MONUMENT FIRE DISTRICT

To: Development Review, El Paso County
From: Jonathan Bradley, Fire Marshal
Subject: Monument Glamping II, AL Special Use
Date: April 10, 2024

The Monument Fire District has reviewed the latest site plan (April 5, 2024 filing) for Monument Glamping II. The fire department, the property owner, and their representatives visited the site to discuss fire department access we have agreed to the following accommodations.

Monument Glamping II
18045 HIGHWAY 83, COLORADO SPRINGS, CO 80908

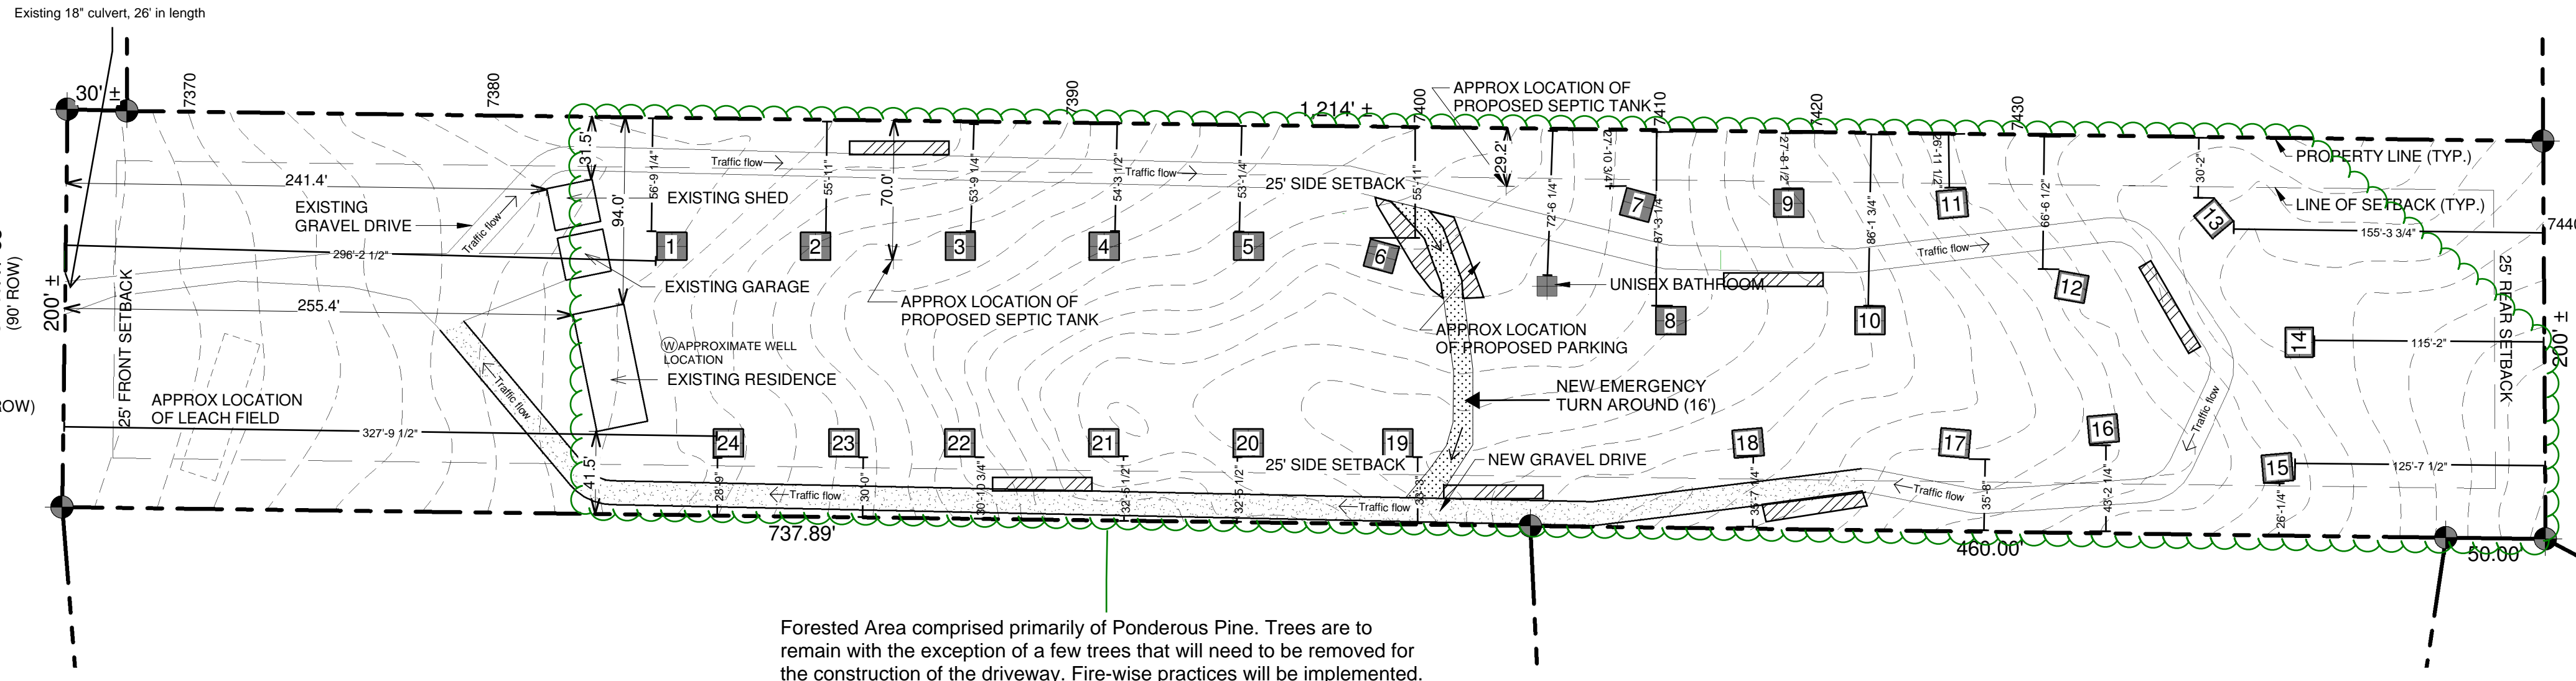
- The fire department will approve the site plan with a 16 foot access road (instead of the previously requested 20 foot road width) under the following conditions:
 - Passable surface turnouts are added to the site development plan (see proposed locations on site plan drawing)
 - The recently added “new emergency turnaround” in the site plan drawing is required in the site development plan.
